Subject: RE: Oxfordshire County Council's response to 19/00607/F Land At Skimmingdish Lane And Land And Roundabout At Bicester Road Launton

Suggested condition wording:

SuDS

Drawing Title  
**COMPOUND A1  
 PLANNING APPLICATION  
 DRAINAGE PLAN**

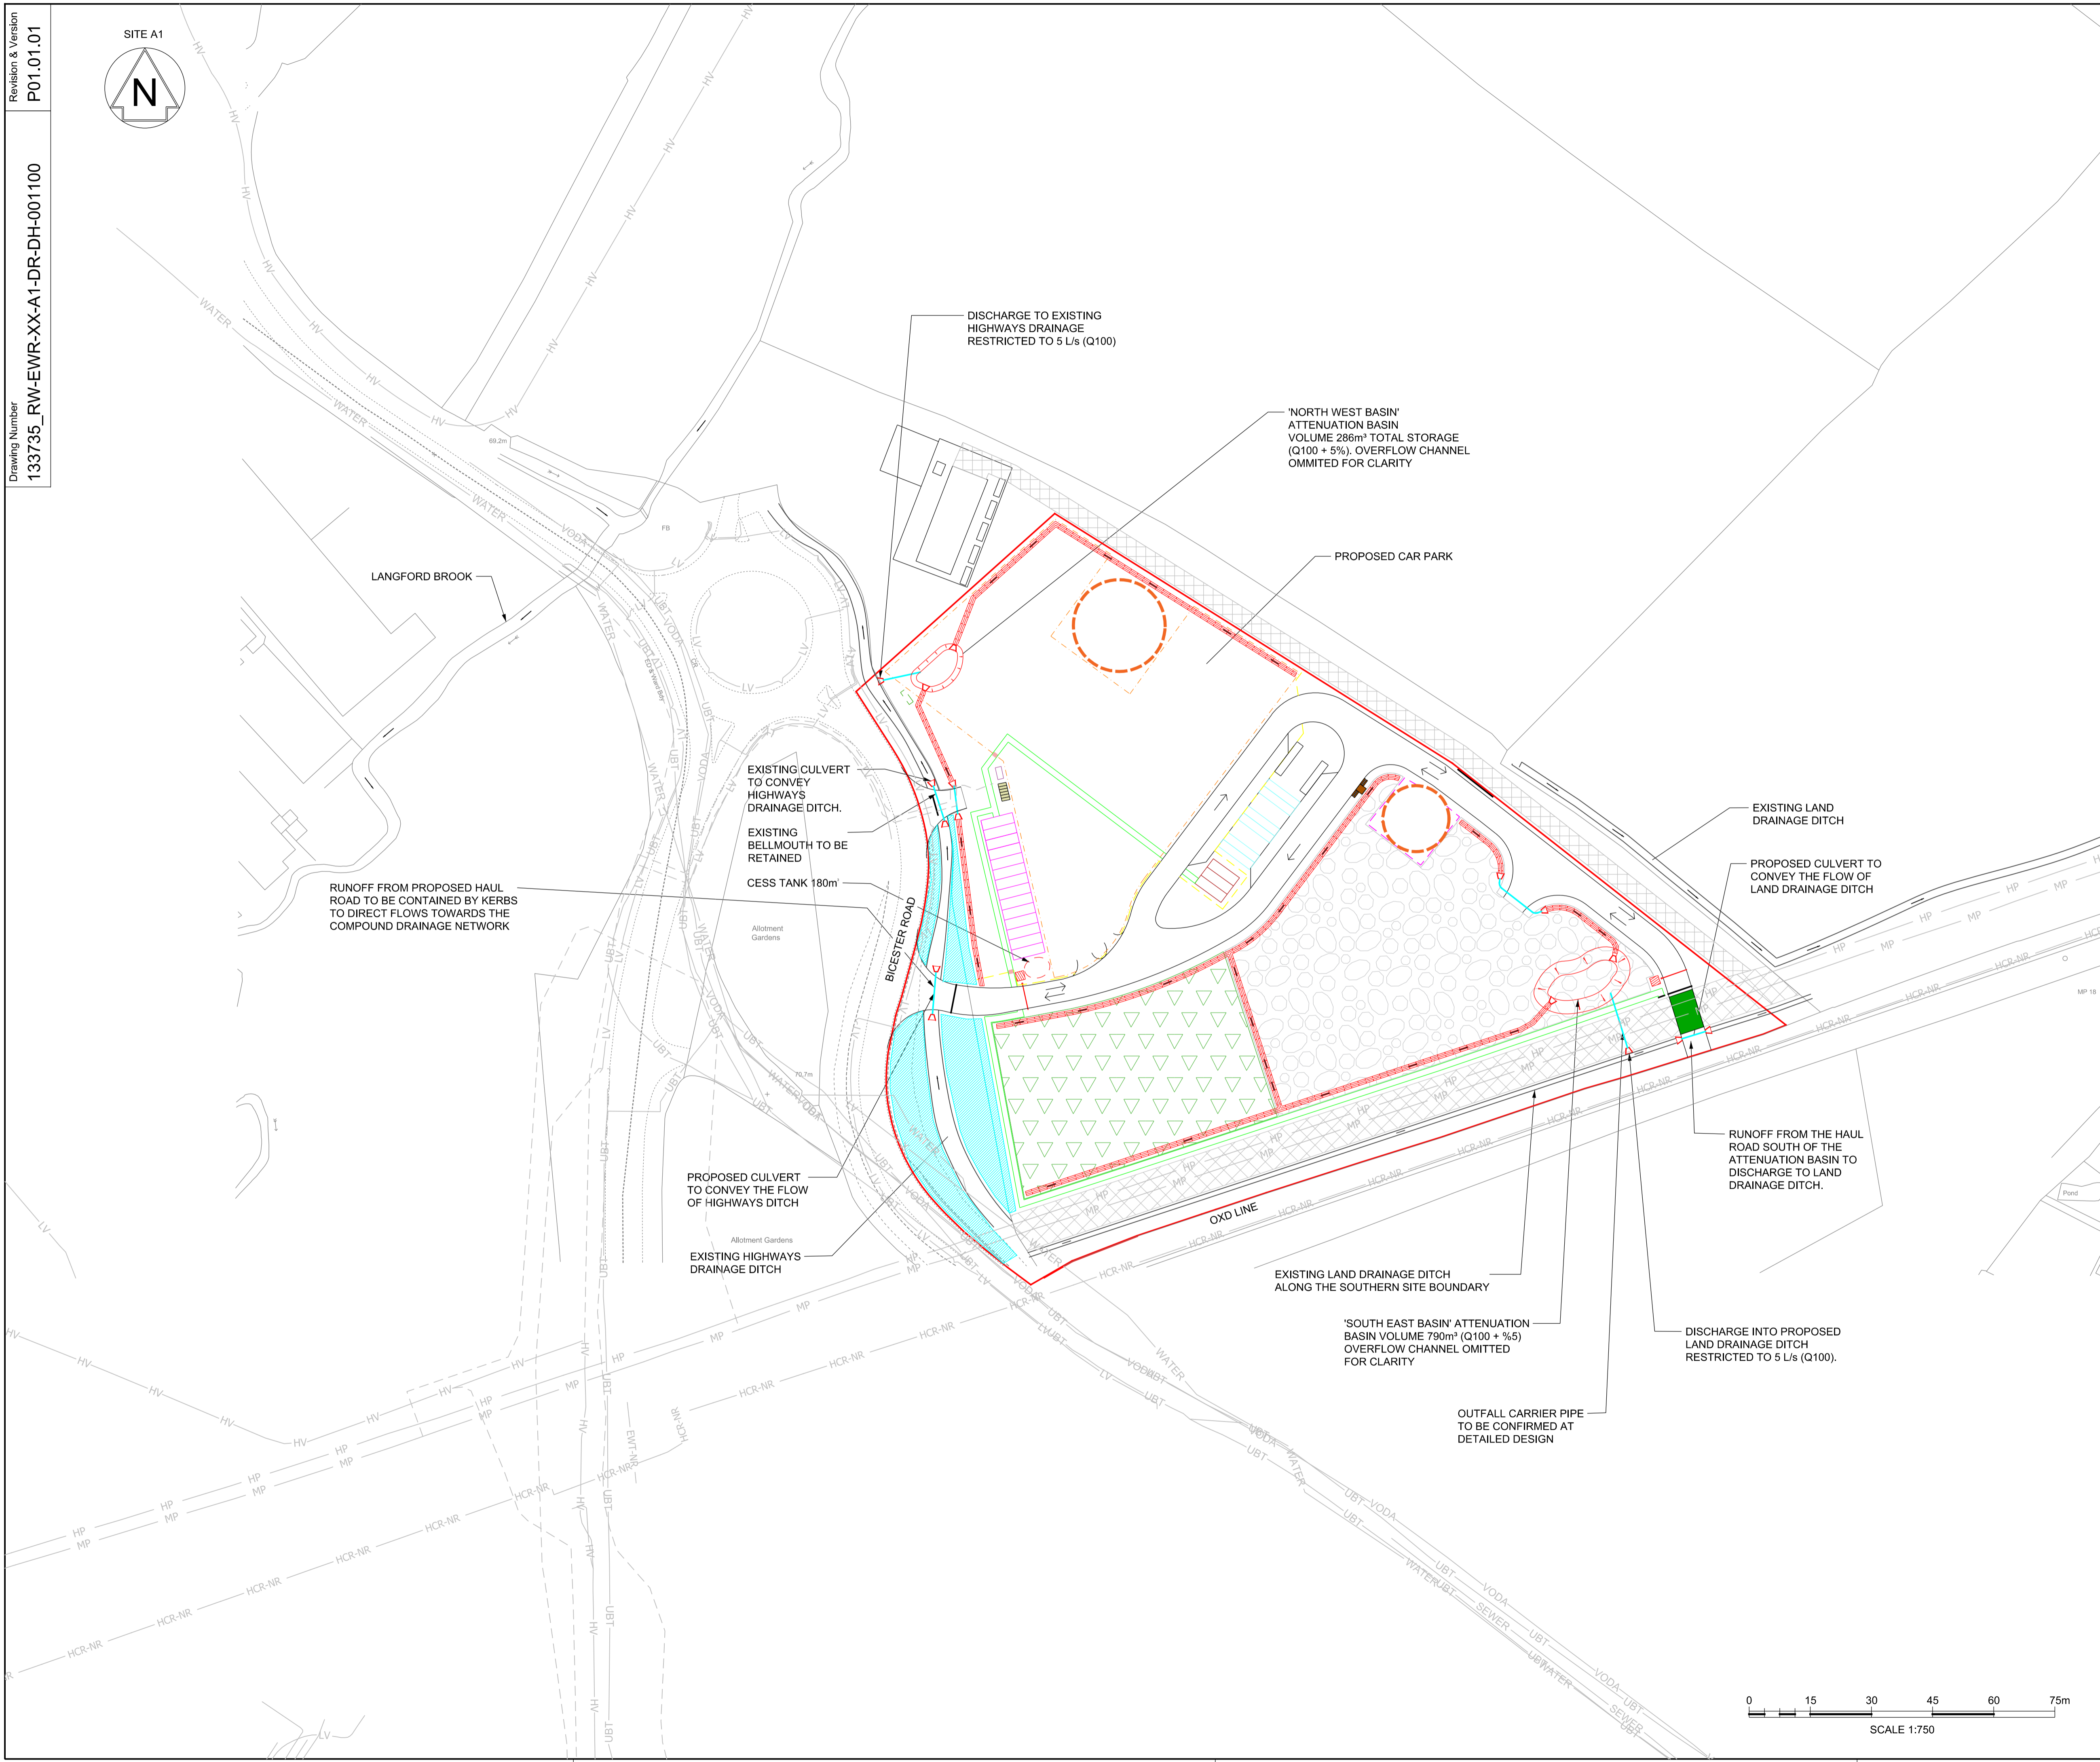
No development shall take place until a detailed design and associated management and maintenance plan of surface water drainage for the site using sustainable drainage methods has been submitted to and approved in writing by the Local Planning Authority, as per the proposed strategy 133735_2A-EWR-OXD-CC_A1-RP-DH-000001 (ProjectWise no.) 133735-EWR-REP-EDR-000022 (eB no.) Rev B01 The approved drainage system shall be implemented in accordance with the approved detailed design prior to the use of the building commencing.

Below ground construction works shall not begin until a surface water drainage scheme for the site, based on sustainable drainage principles and an assessment of the hydrological and hydro-geological context of the development, has been submitted to and approved in writing by the local planning authority. The scheme shall subsequently be implemented in accordance with the approved details before the development is completed. The scheme shall also include:

Detailed drainage layout with pipe numbers

Evidence that highways are willing to allow discharge to existing highways drainage as proposed on plan 133735_RW-EWR-XX-A1-DR-DH-001100
